Project: Cimarron Service Center
2283 Waynoka Rd.
El Paso County, Colorado

SP1
SITE PLAN
Sheet 1 of 1

SP1
 SITE PLAN
 Sheet 1 of 1

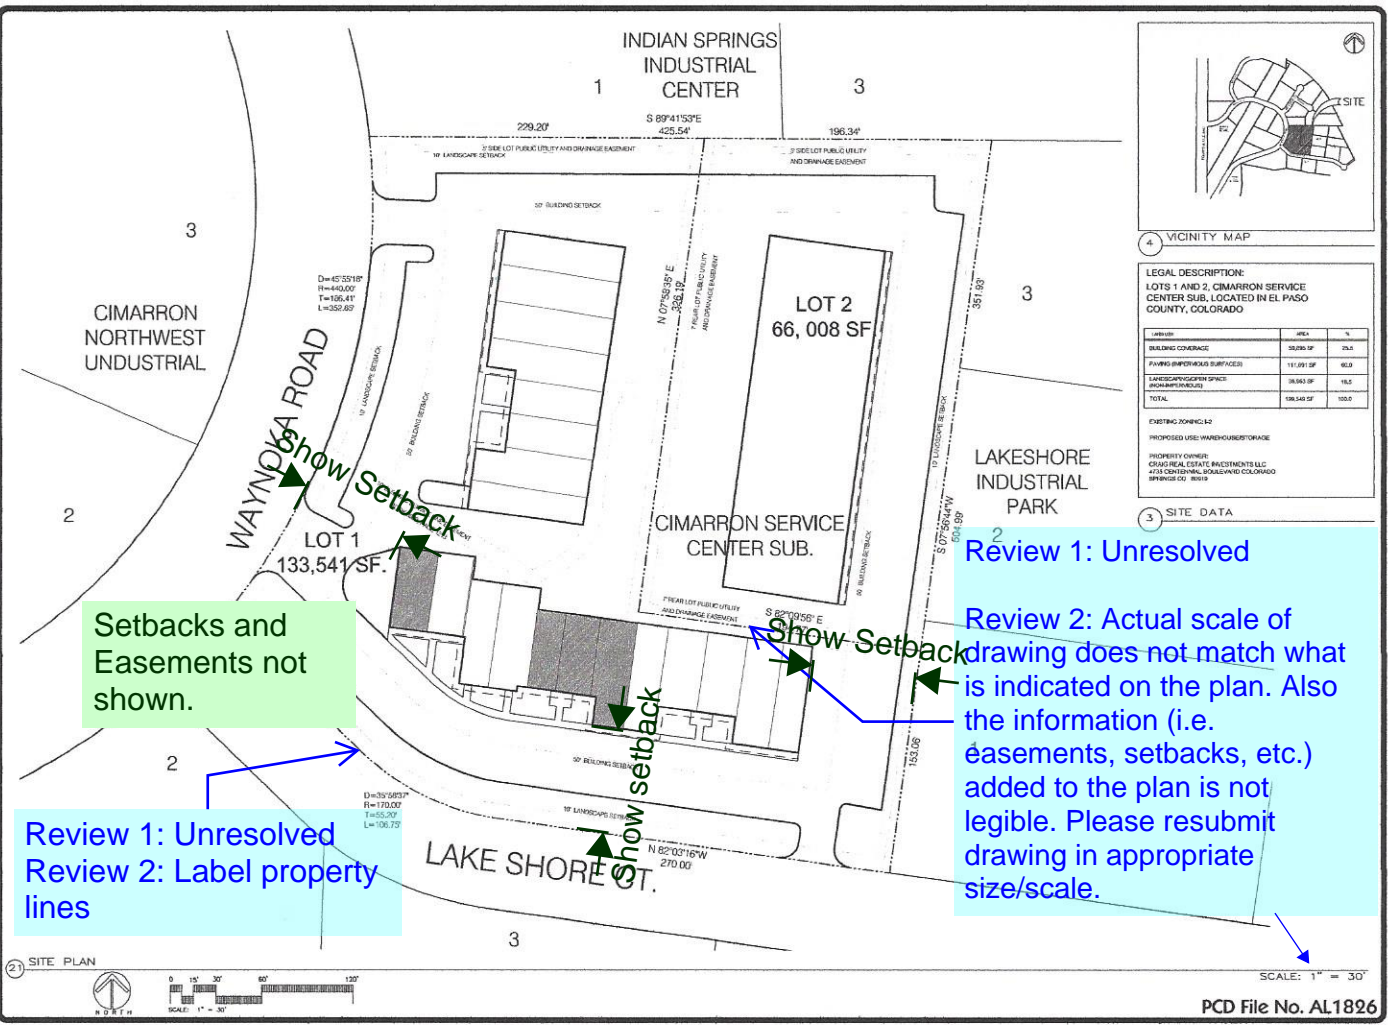
Show all easements indicated on the plat

Actual scale of drawing does not match what is indicated on the plan. Also the Site Data information is not legible. Please resubmit drawing in appropriate size/scale.

Label property lines

Show existing setbacks.

Plat No. 8833 indicates this length as 270'. Revise accordingly.

Show all easements indicated in the title commitment.

① First Floor Plan - 2275
1/32" = 1'-0"

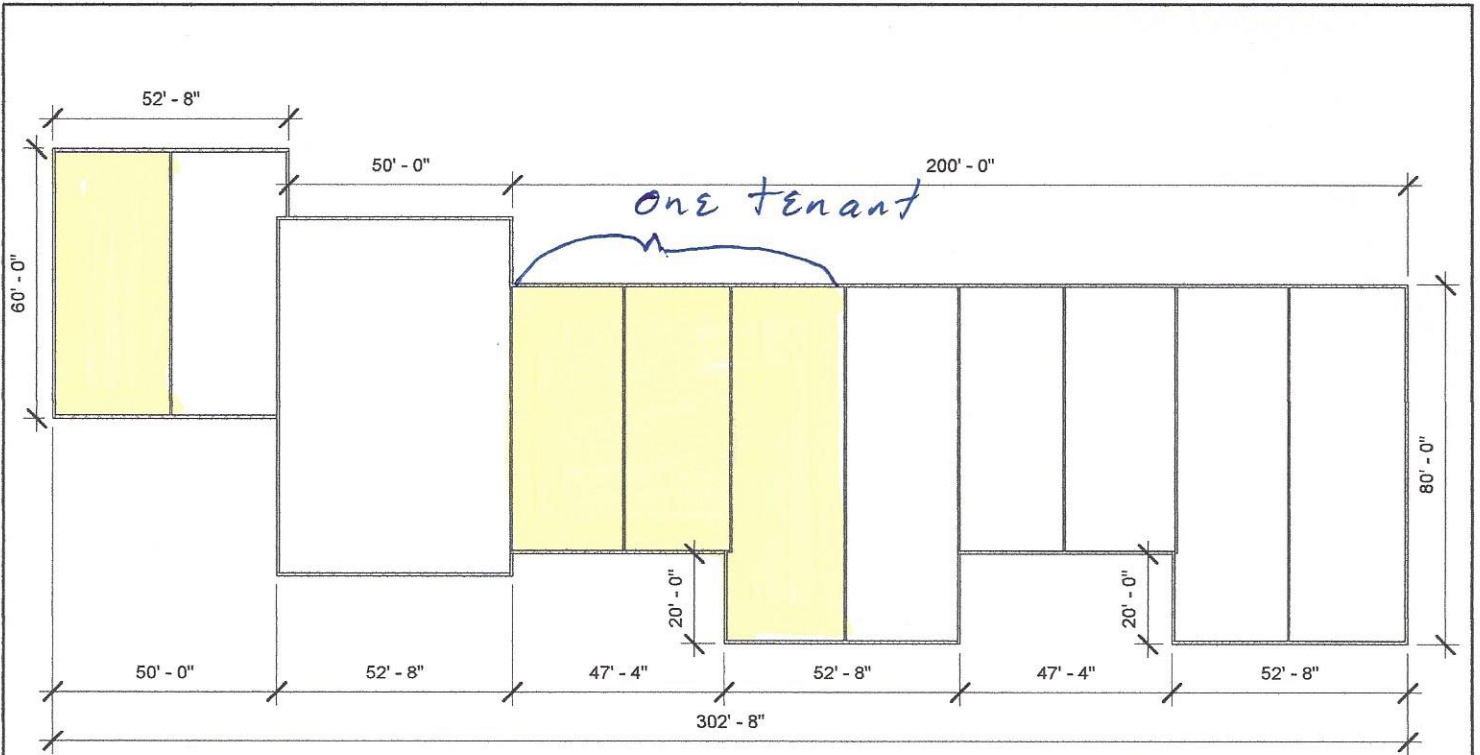
Include the units where the vehicle repair garages will take place. (attach the tenant map and mark the building where they take place).
